# WHITESTONE SOLAR FARM

## Volume 6: Environmental Statement

### 6.15 Chapter 15: Socio-Economics, Tourism and Recreation, and Land-Use

Application Document ref. EN0110020/APP/6.15

**Whitestone Solar Farm
Environmental Statement Volume 3
Figure 15.6
Agricultural Land Classification
Sheet 1 of 1**

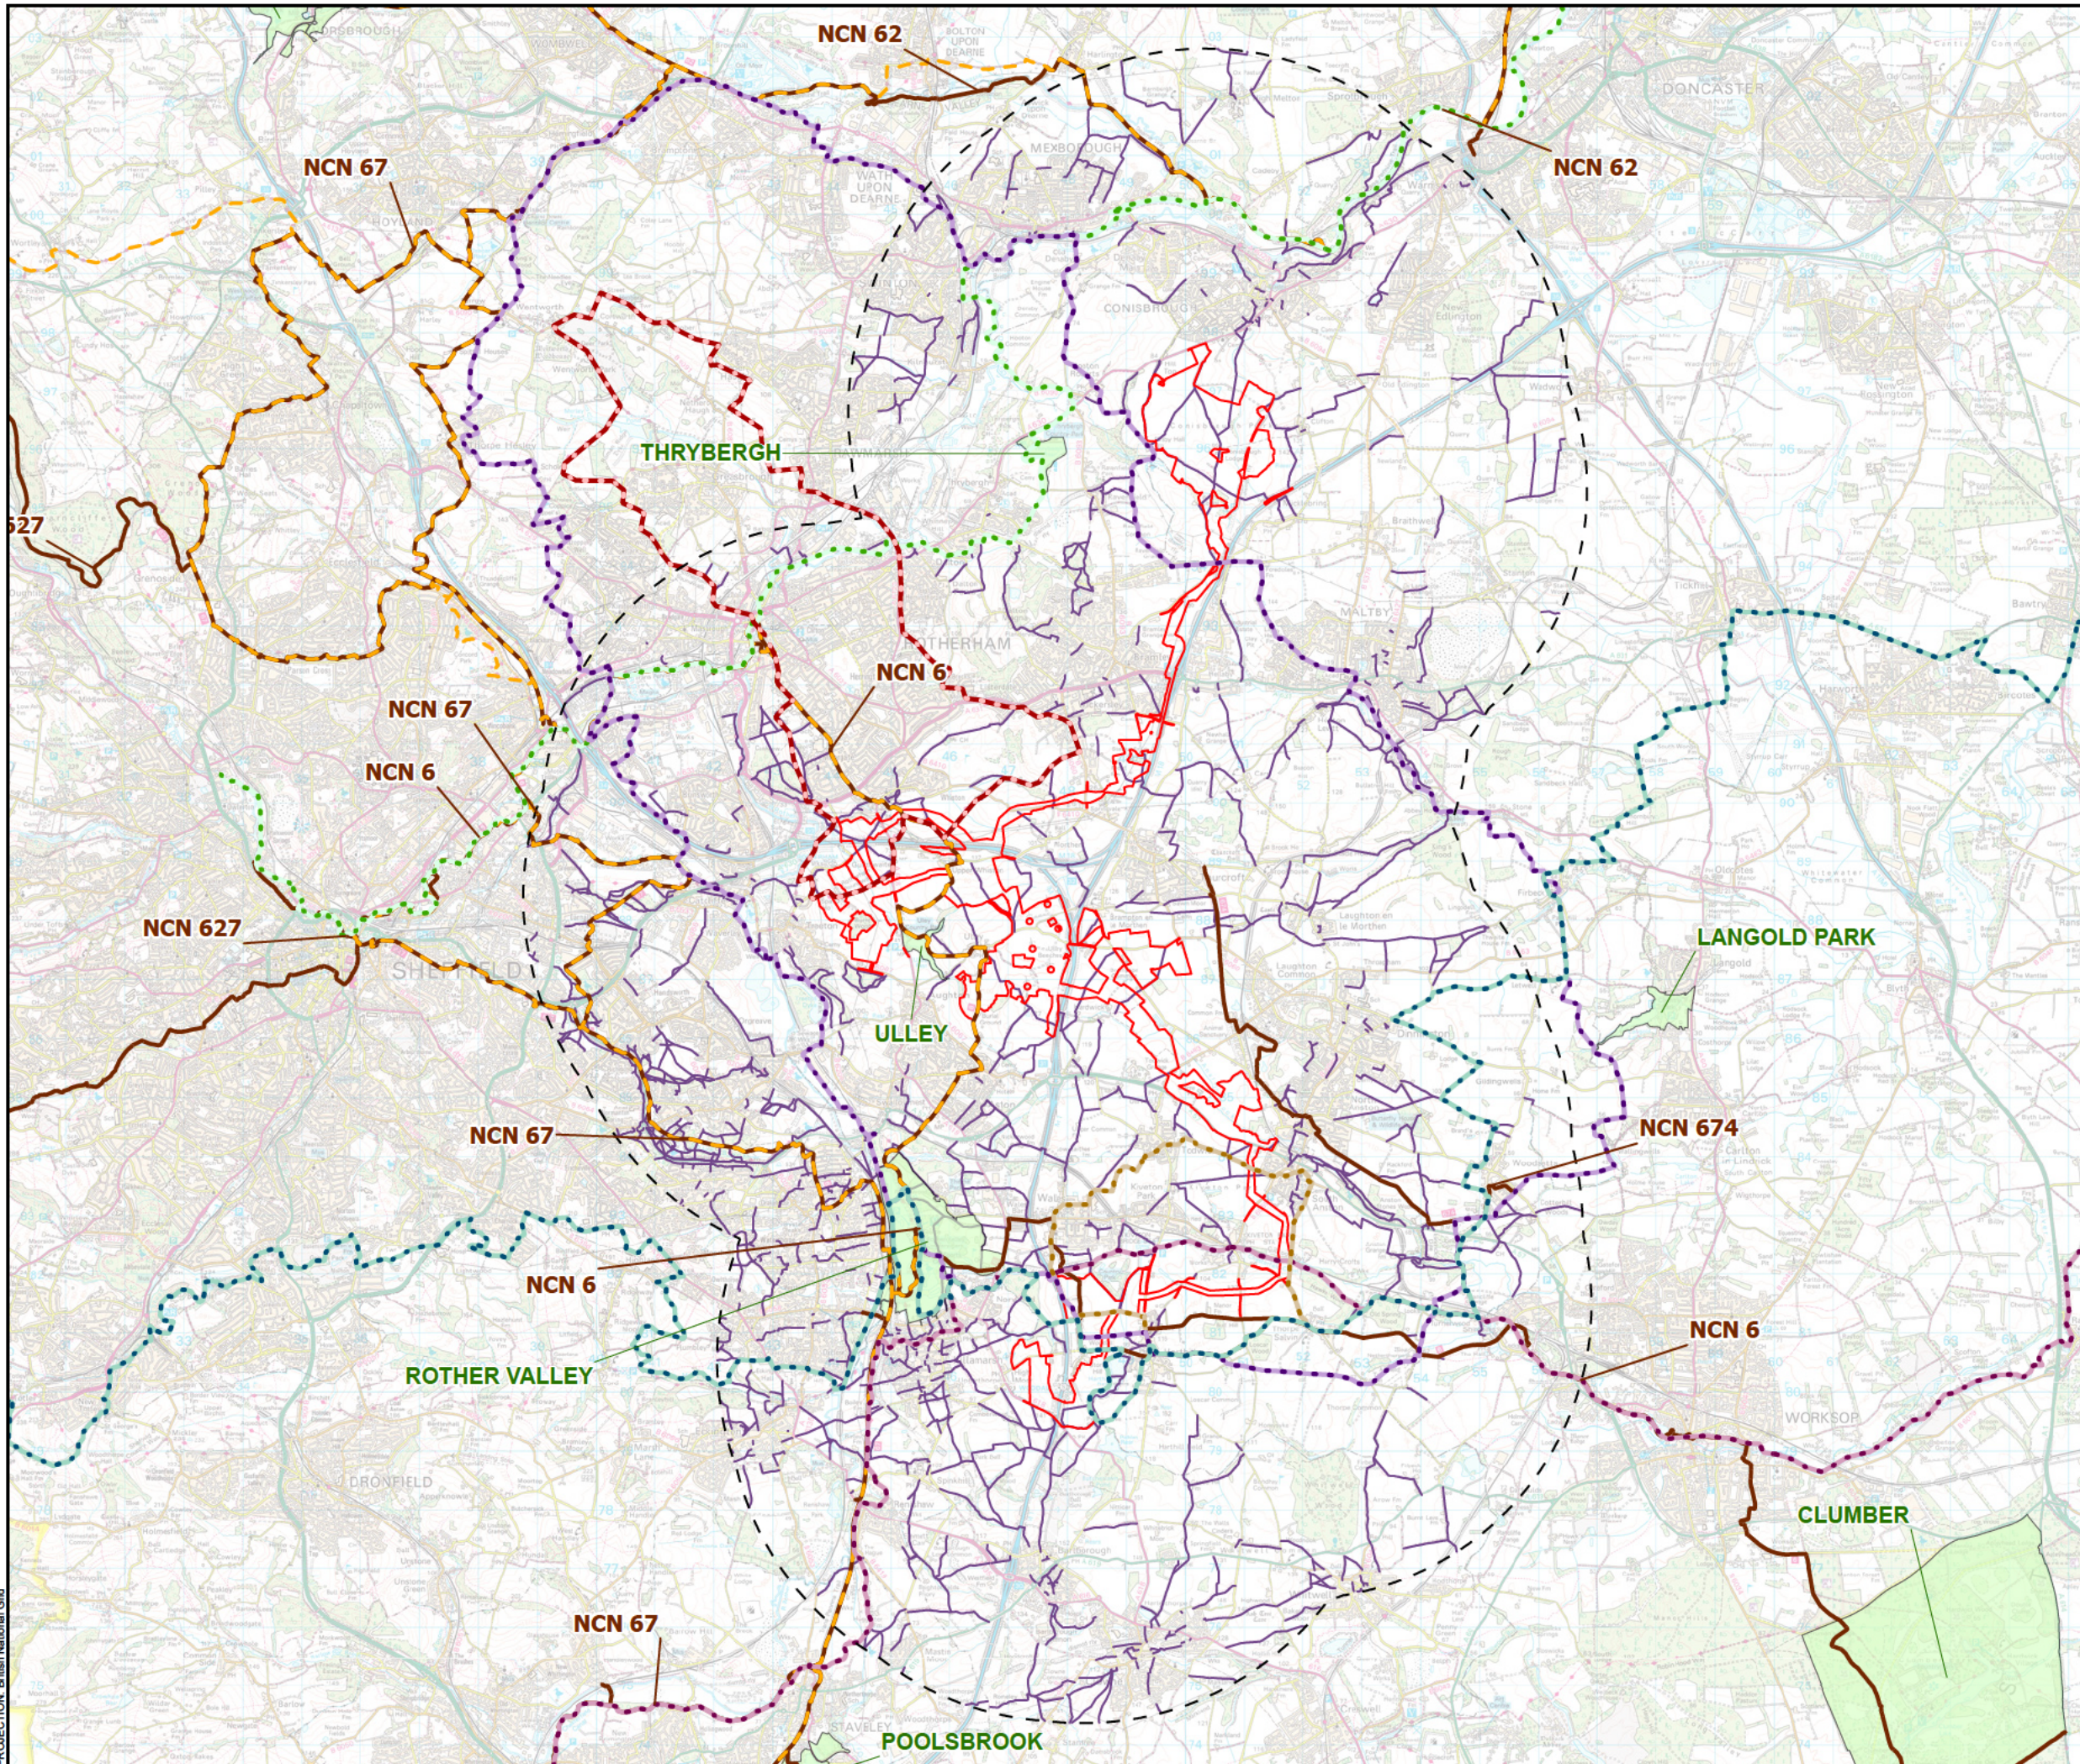
CDC	CDC noted that Figure 15.6, Volume 2 – Agricultural Land Classification Plan indicated that a significant proportion of Whitestone 1 had yet to be surveyed and so CDC would not be able to offer any detailed comments.	ALC surveys have been undertaken across the entirety of W1, W2 and W3. The findings of these surveys are shown in <b>ES Volume 3, Figure 15.6: Agricultural Land Classification [EN0110020/APP/6.19]</b> and have informed the baseline and assessment in this Chapter. Desk-based review of ALC classification of land within the Cable Corridors has been undertaken. Further information is provided in <b>ES Volume 2, Chapter</b>	<b>ES Volume 3, Appendix 9.6: Agricultural Land Classification Report [EN0110020/APP/6.20]</b> <b>ES Volume 3, Figure 15.6: Agricultural land Classification</b> Section 15.5 and Section 15.7 of this Chapter.
